Huntlee New Town Residential Subdivision Stage 1 (MP 10_0137 MOD 11)

The Biodiversity and Conservation Division (BCD) of the Department of Planning Industry and Environment (the Department) has reviewed the submission for Modification 11 'Section 4.55(1a) Modification Application MP_10_0137 (Mod 11) Huntlee New Town, Branxton' prepared by Ethos Urban, and dated 7 November 2019. BCD understands Mod 11 involves the creation of one additional residential lot within residential Stage 16 (R16) as a result of the subdivision of superlot 222, and one additional Town Centre commercial lot within TC1, delays in the timing for the road upgrade, minor road and lot boundary alignment amendments, and a request to change conditions of consent.

BCD's detailed comments

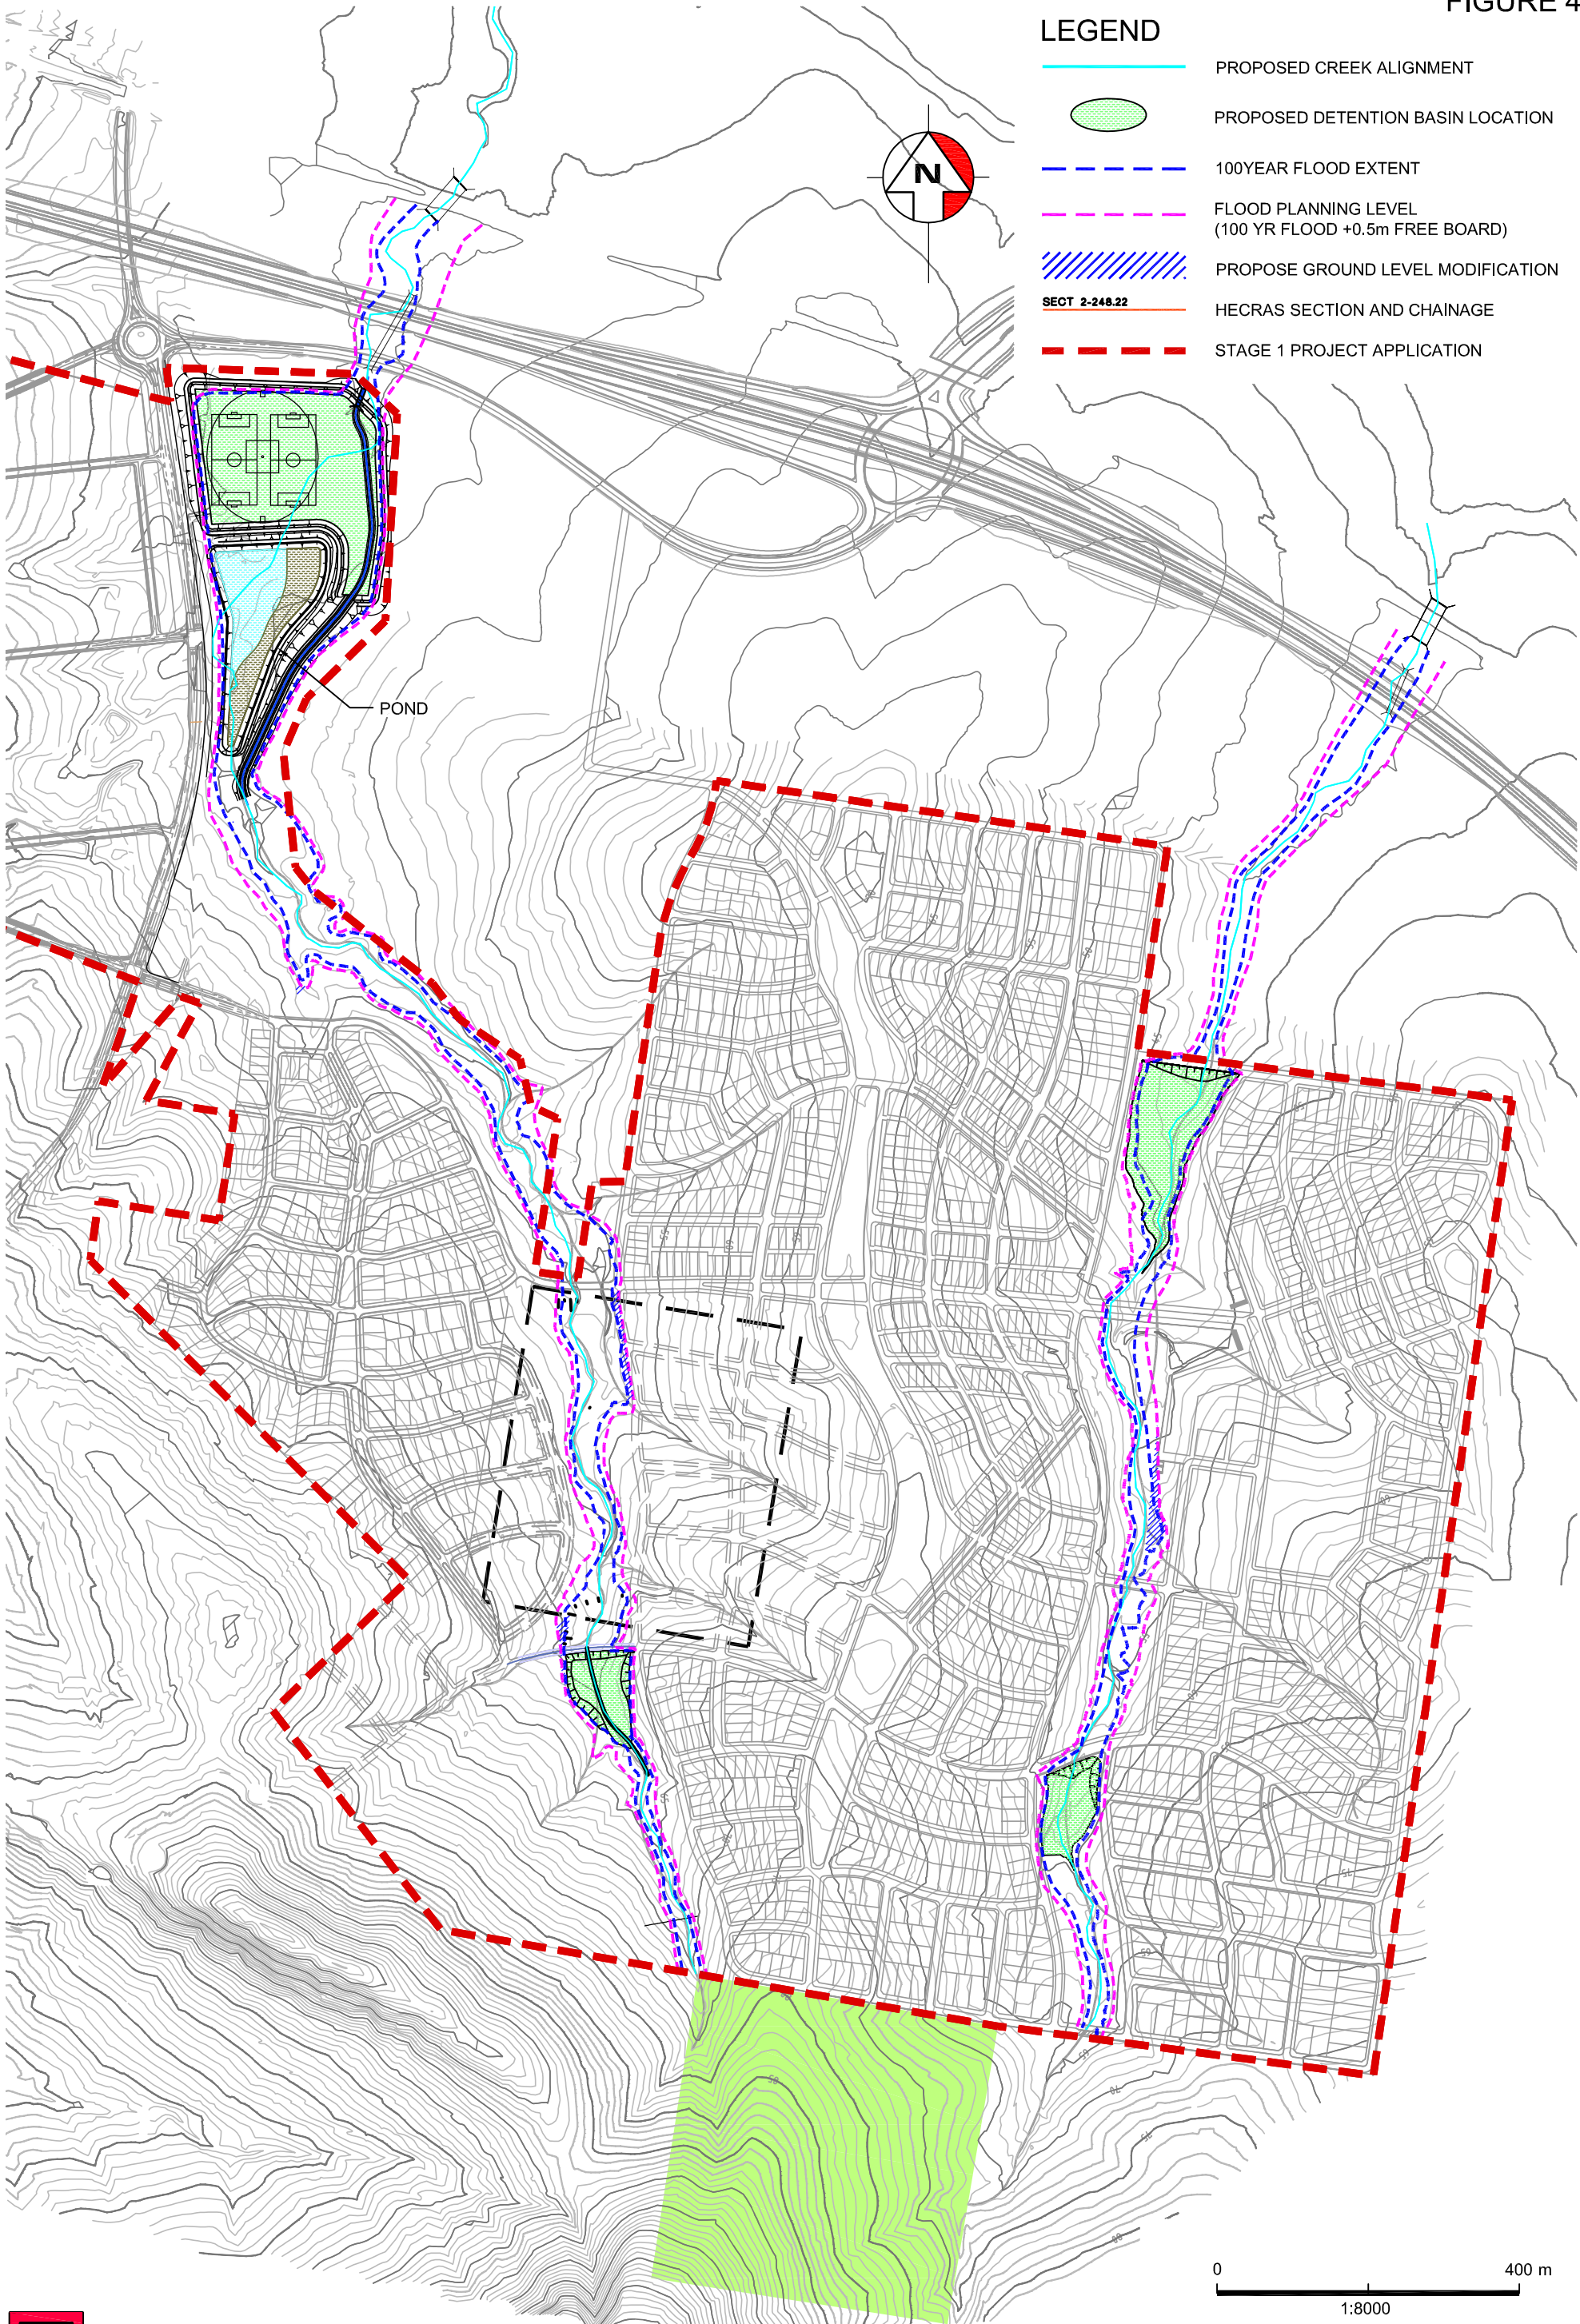
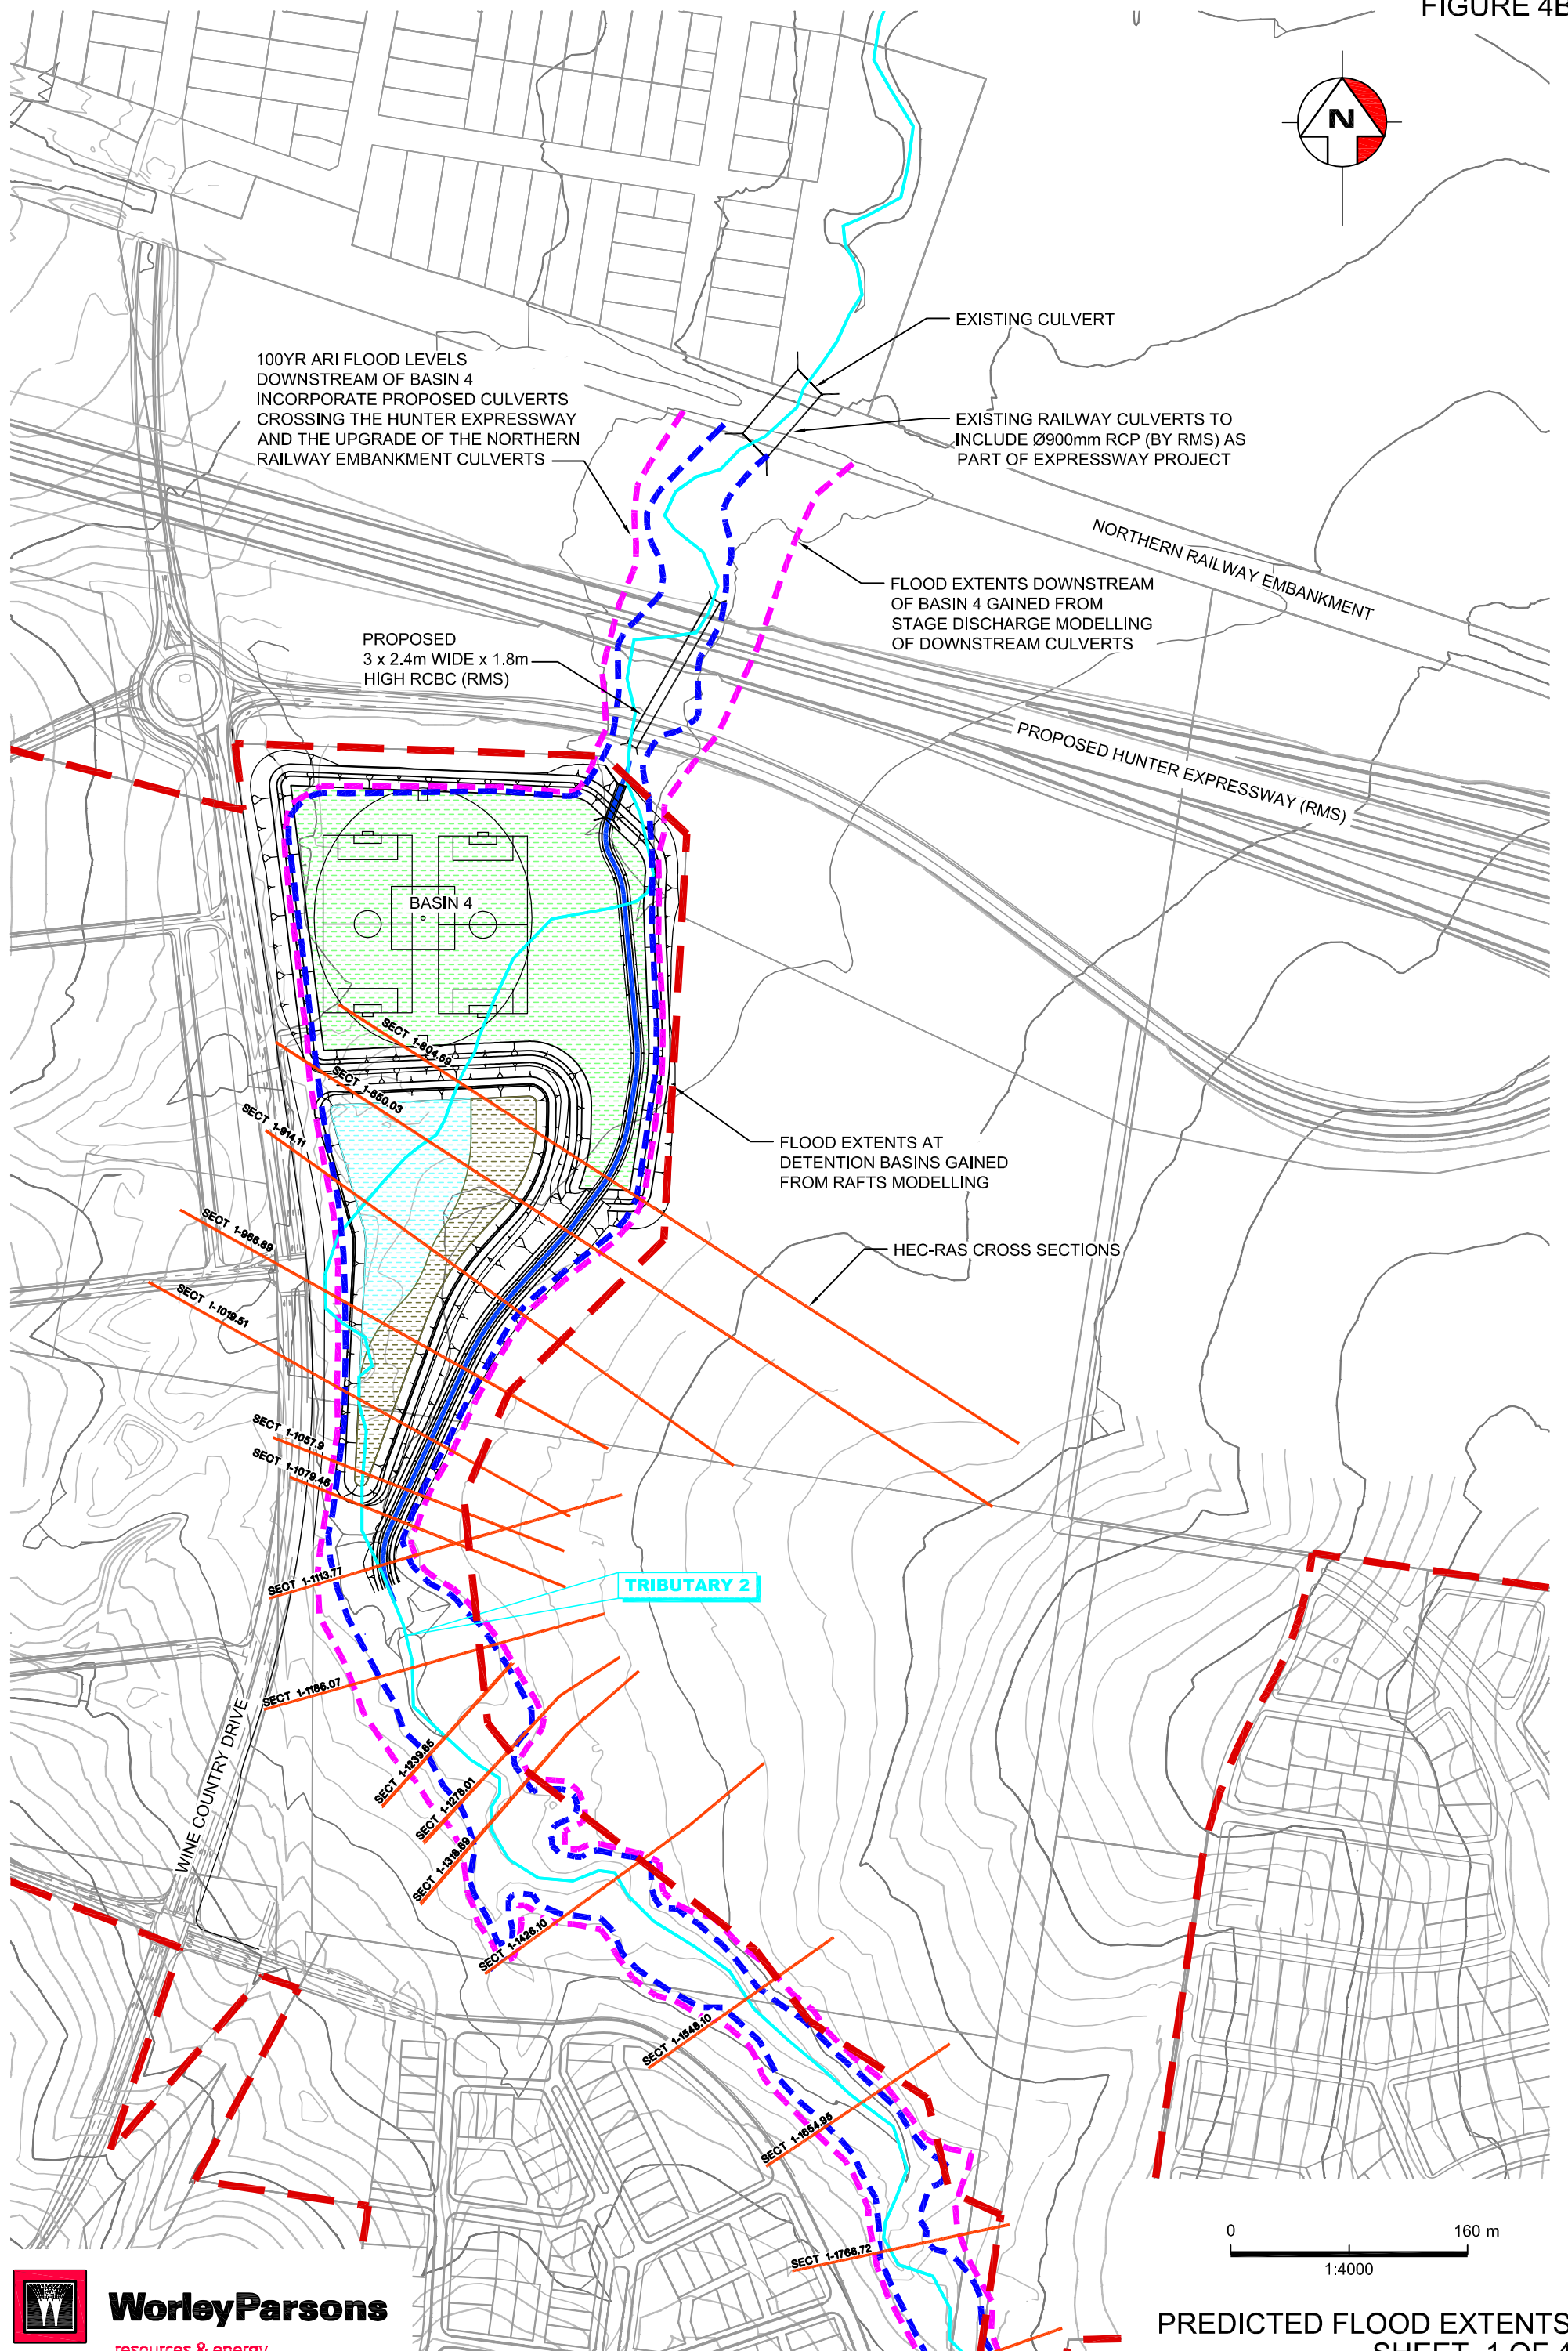
Attachment E, Huntlee Stage 1 Constraints on Amended lots shows the flood extent on the proposed lots. This plan is of too small a scale to determine if encroachment into the flood extent has occurred. Mod 11 presents the Worley Parsons flood map in support of the changes. The flood map is for the original subdivision and the flood extent shown on Attachment E differs from that on the Worley Parsons mapping.

Flood mapping needs to be updated to reflect the revised on-site detention structures, lot layout and flood extent. Mapping provided is to overlay flood extent on the proposed lot layout at adequate scale to enable impact to be assessed.
